**East of England Ambulance Service NHS Trust**

Date: 23 February 2026

Our Ref: East Park Energy/ZM

**BSSL Cambsbed 1 Limited for an order granting development consent for the East Park Energy project**

Client
BSSL Cambsbed 1 Ltd
Project
East Park Energy
Drawing Title
**Indicative Construction Access
and Compounds
Key Plan (Sheet 0 of 5)**

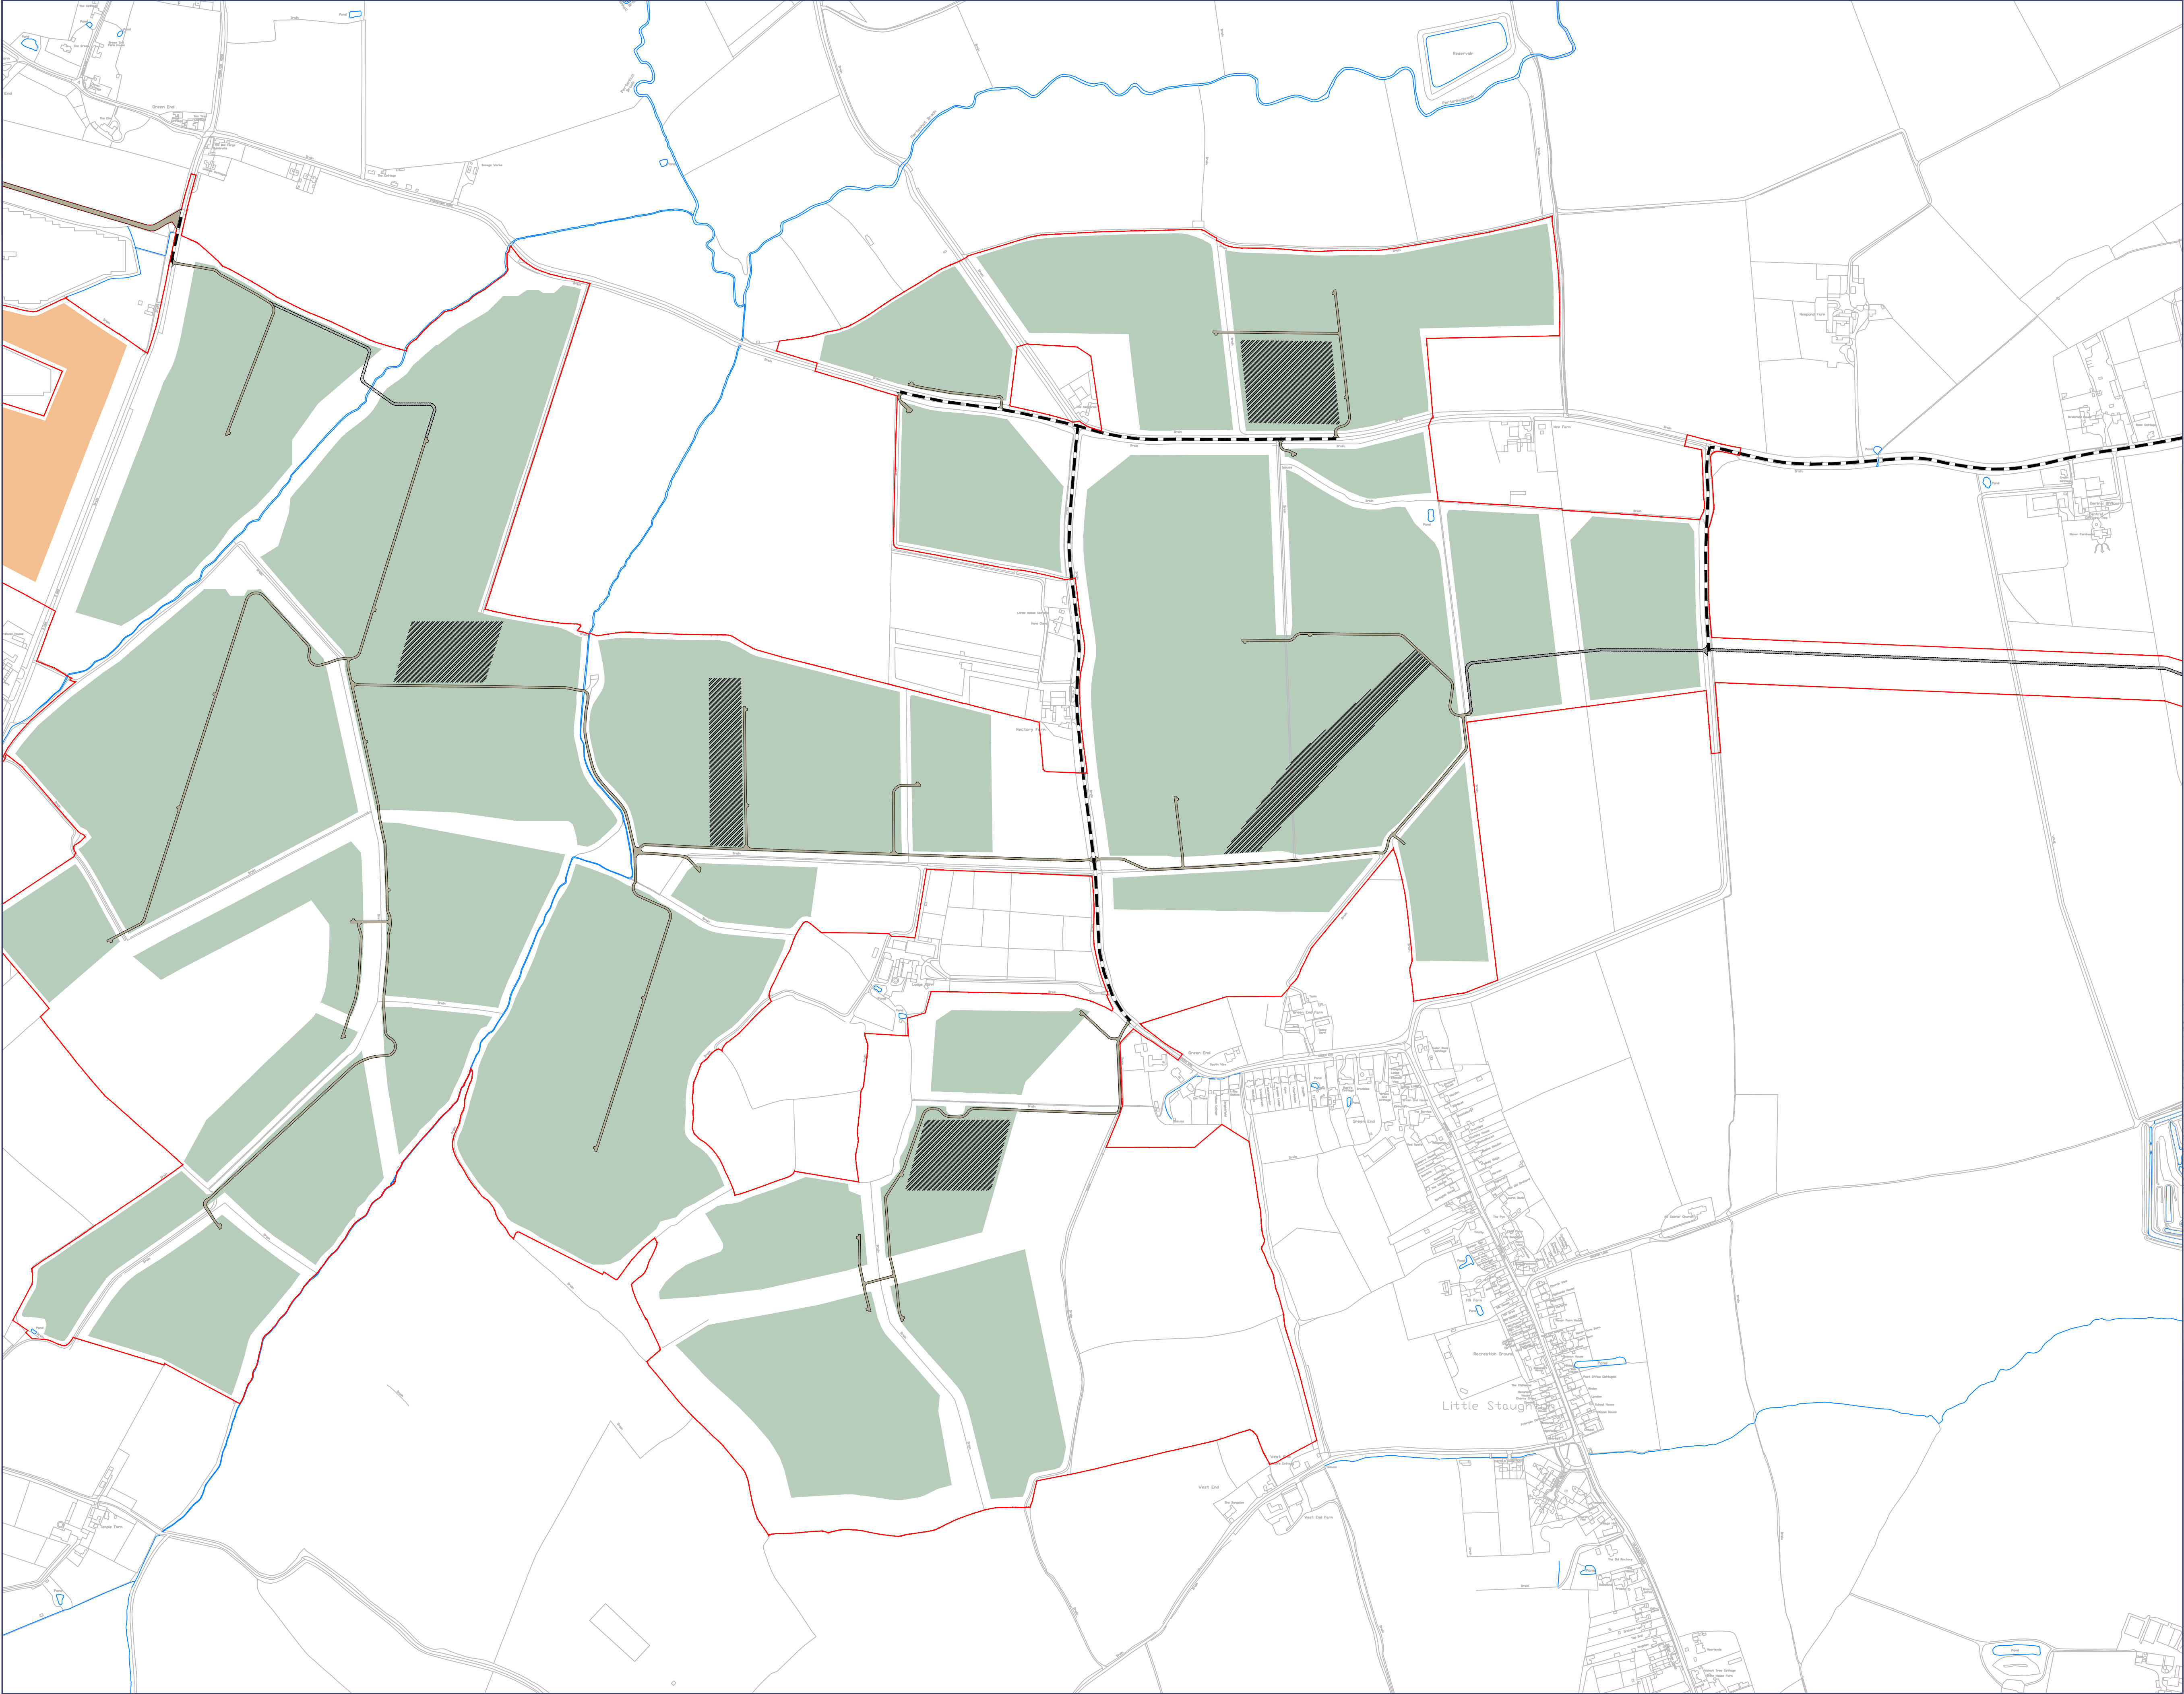
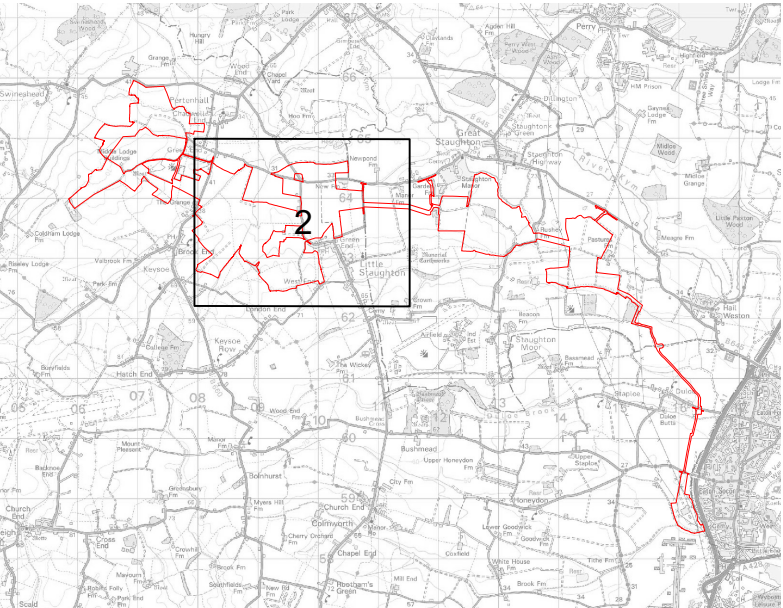
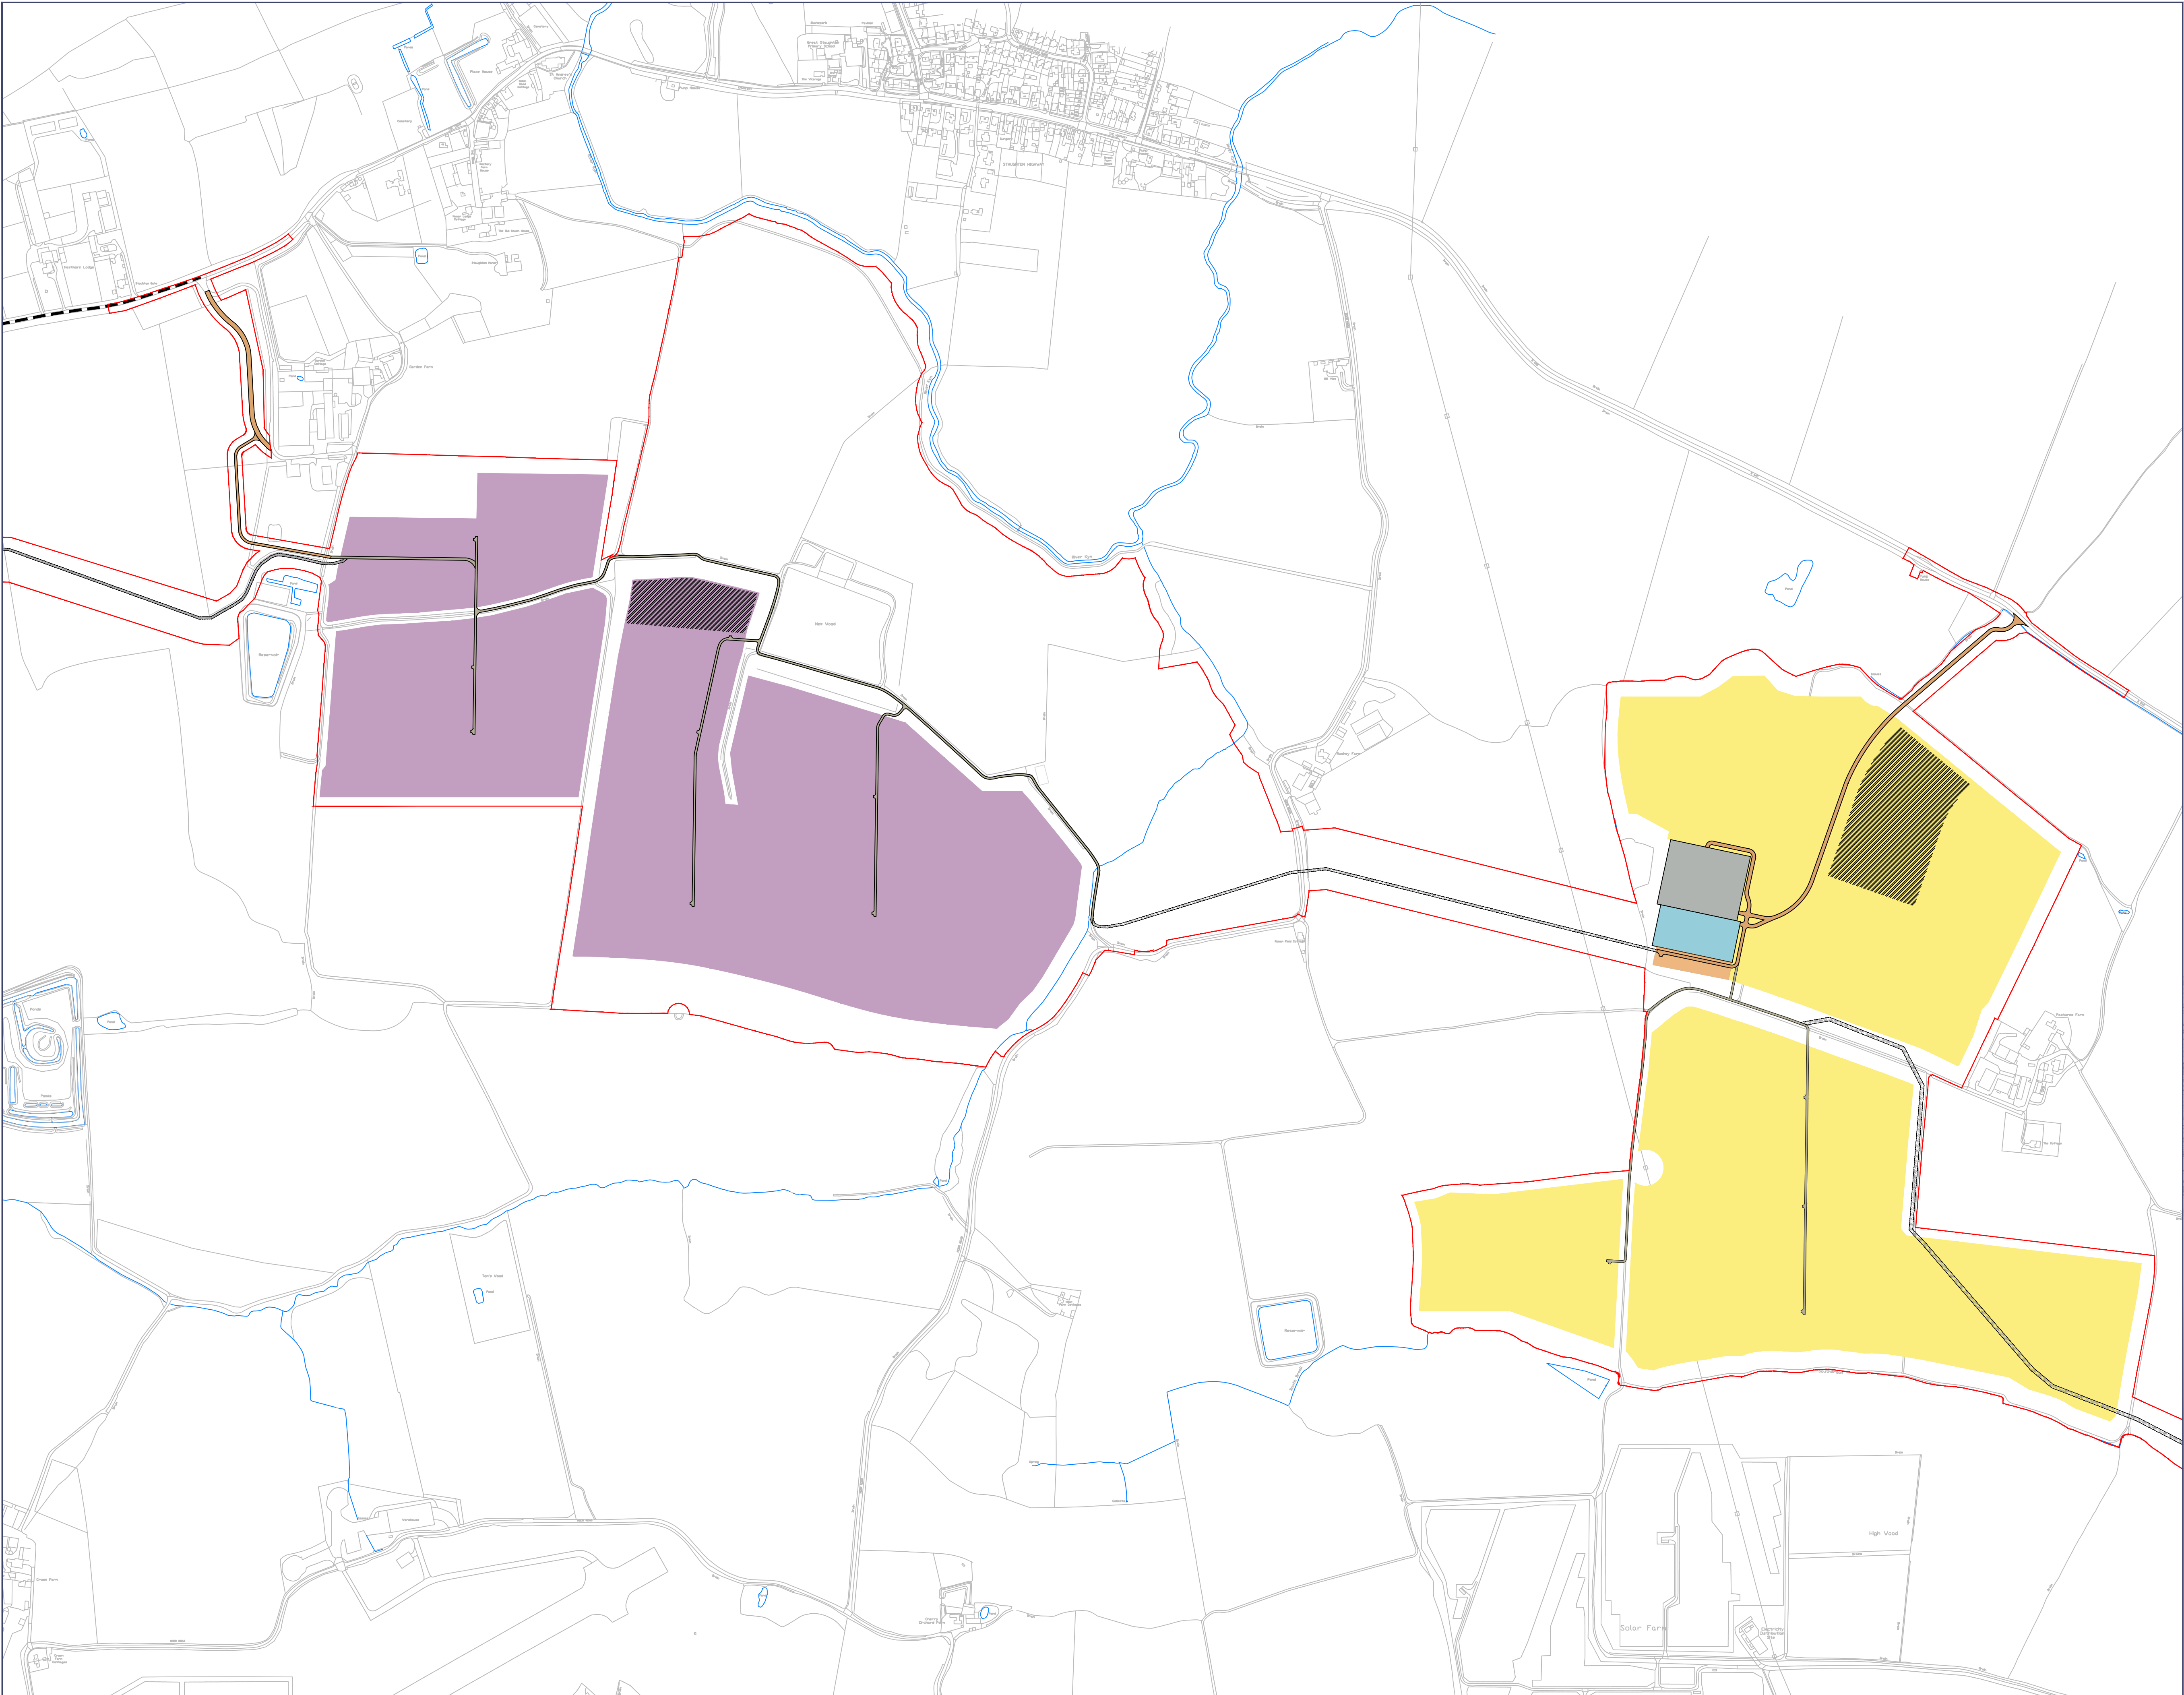
Mitigation is sought by agreeing a Statement of Common Ground with BSSL Cambsbed 1 Limited to ensure effective transport management through advanced notification of:

- AILs routes, movement timeline
- Road closures and diversions.
- Enabling works of main compound, access at sites A-D
- Construction of BESS
